# Rezoning Transportation Analysis

Petition Number: 2020-169

General Location Identifier: Tax ID: 15705424

Date	Description
11-30-20	First Review (WB)

DEVELOPMENT STANDARDS

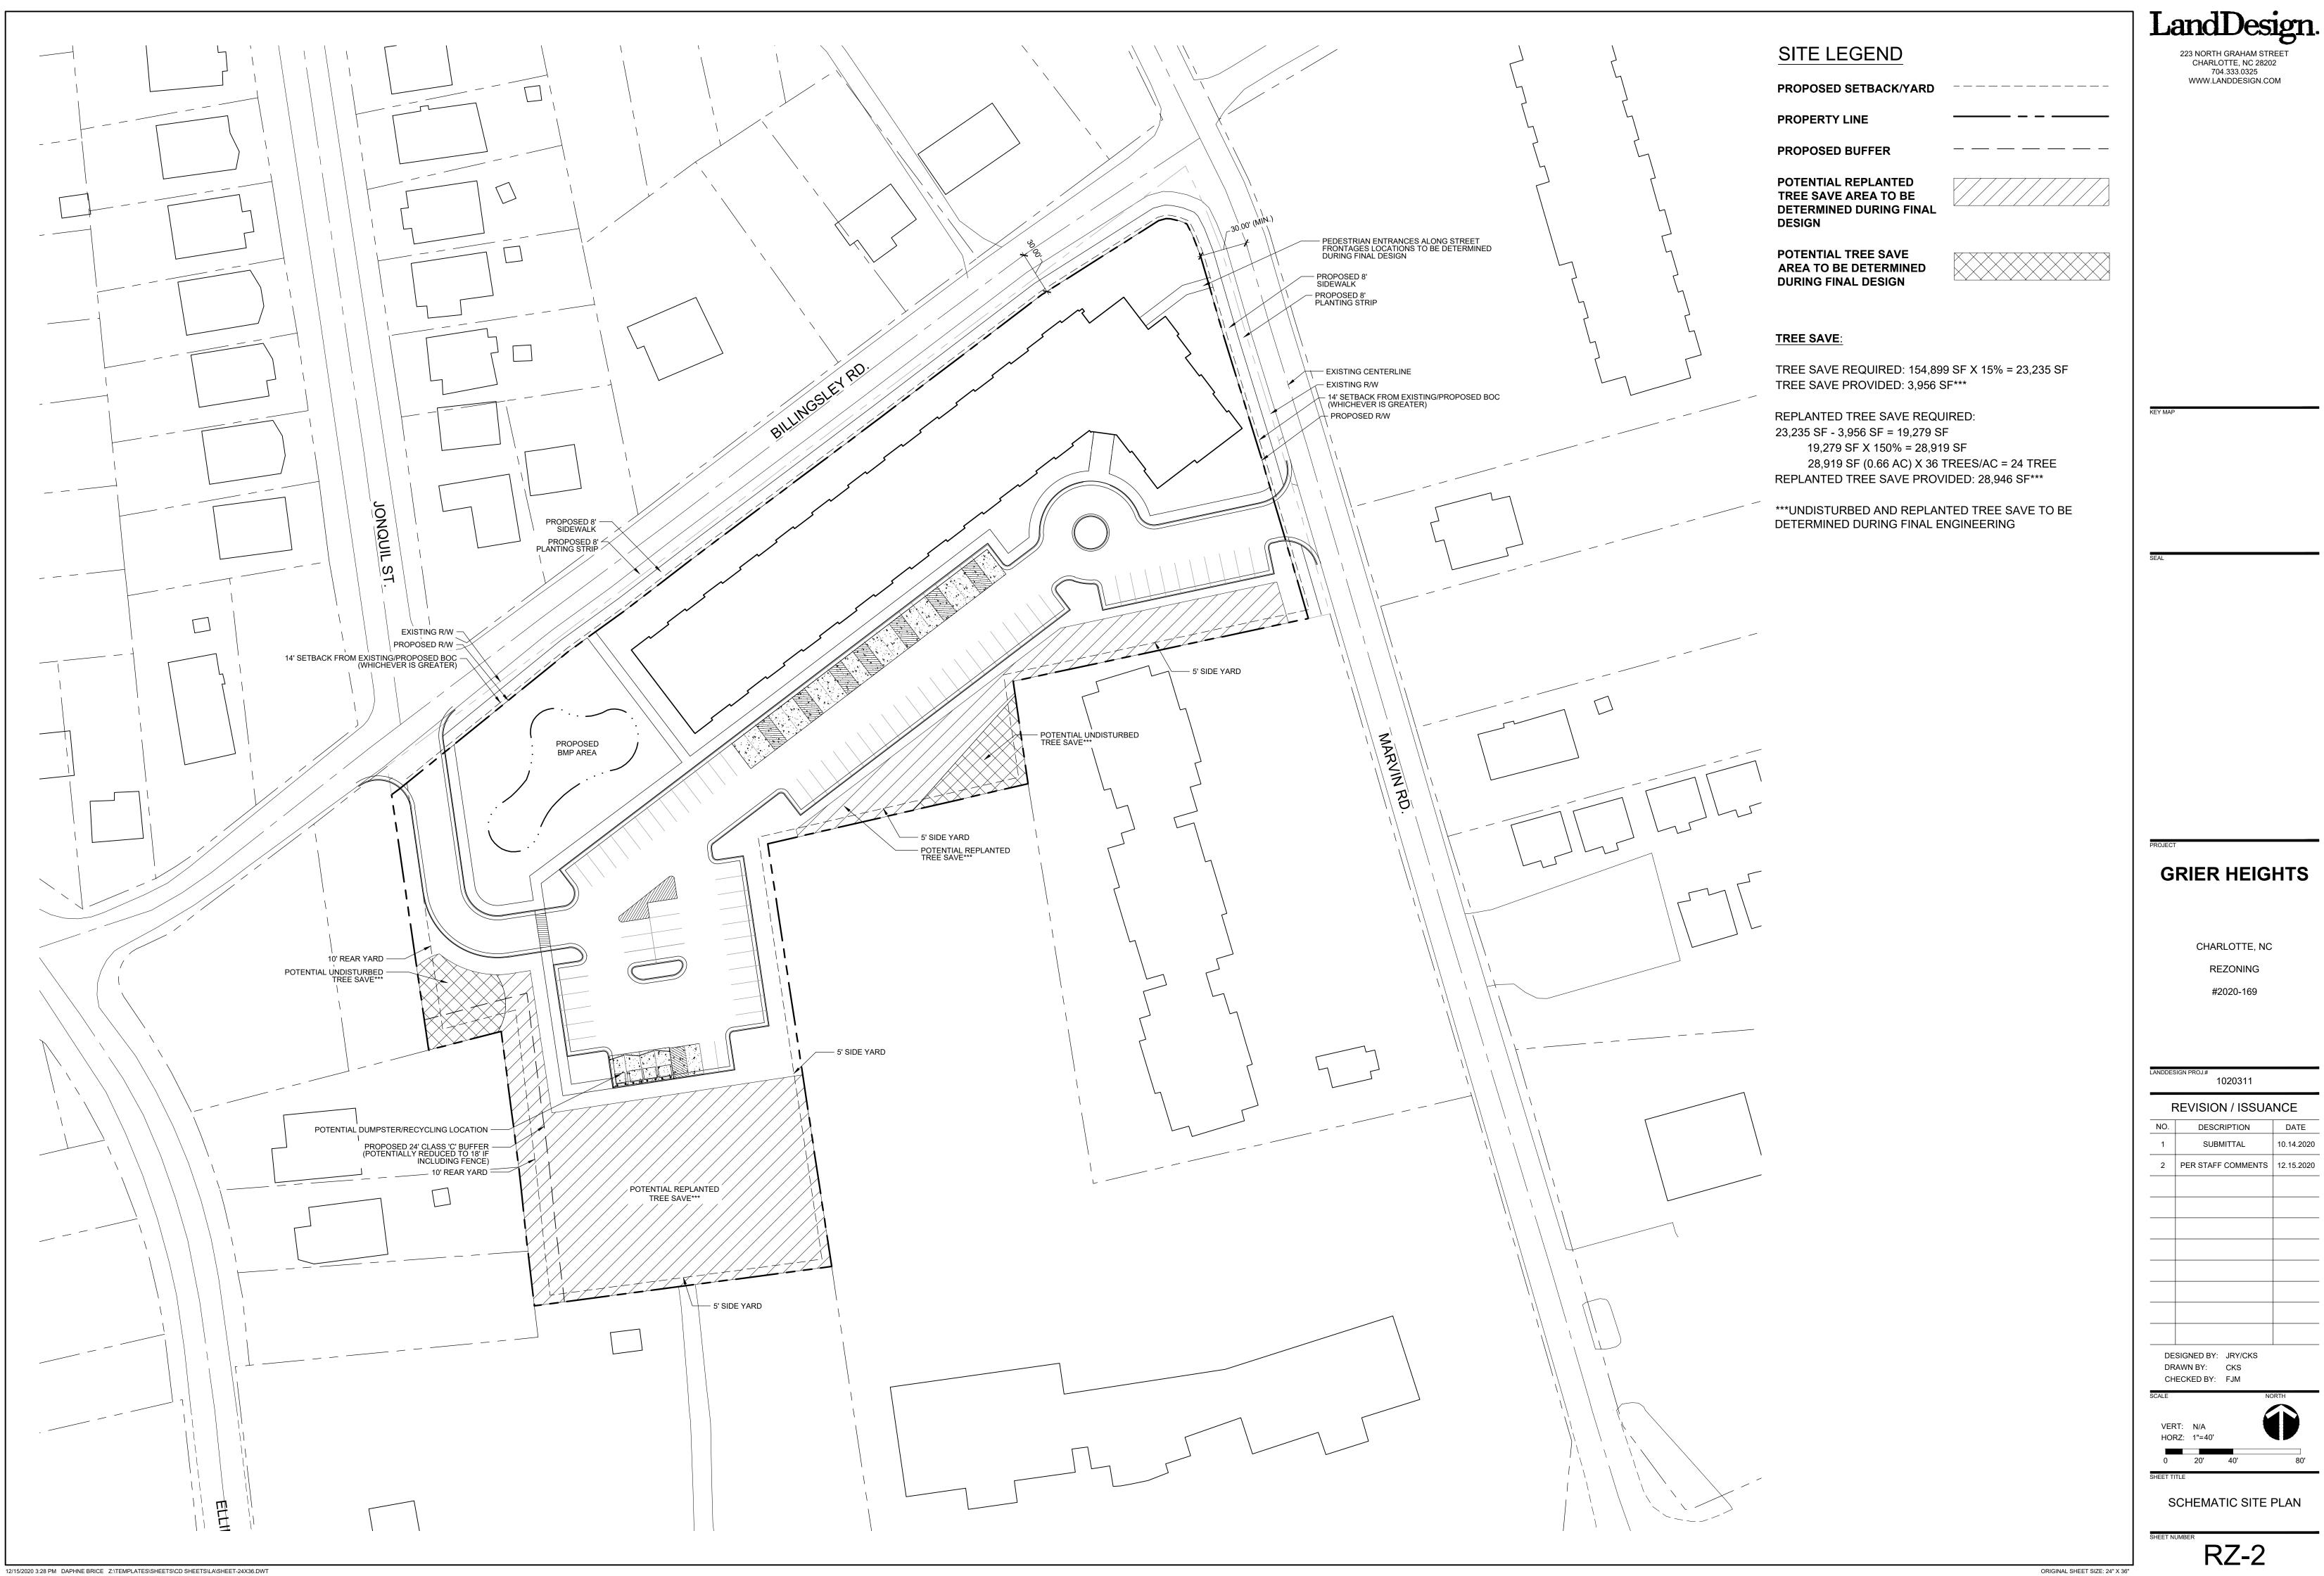
1. **Curbline:** The proposed zoning district has a setback measured from back of the existing or proposed future curbline.
  - a. **Billingsley Road:** The future location of curb and gutter is in its existing location. Label and dimension the curb and gutter from the centerline for each road on the site plan.
  - b. **Marvin Road:** The future location of curb and gutter is in its existing location. Label and dimension the curb and gutter from the centerline for each road on the site plan.
2. **Traffic Study:**

A Traffic Impact Study (TIS) is not necessary for the complete review of this petition due to the site generating less than 2,500 daily trips. If during the permitting process the site generates more than 2,500 daily trips, then a traffic study will be required.
3. Revise site plan and conditional note(s) to commit to dedicate 30' (minimum) right-of-way from the road centerline. The site plan shall label and dimension the right-of-way from the road centerline.

4. The proposed dwelling units exceeds 12 per acre. Per Chapter 20 Subdivision ordinance, site plan and conditional note(s) revisions are needed to commit to construct an 8-foot planting strip, and 8-foot sidewalk along Billingsley Road and Marvin Road. The wider sidewalk also meets the Charlotte WALKS Policy.

5. Add a site plan note specifying dedication and fee simple conveyance of all rights-of-way to the City before the site's first building certificate of occupancy is issued is needed. CDOT requests rights-of-way set at 2' behind back of sidewalk where feasible.
6. Add a site plan note specifying that all transportation improvements will be approved and constructed before the site's first building certificate of occupancy is issued is needed. The petitioner may phase transportation improvements if said improvements and phasing are explicitly described in site plan notes.
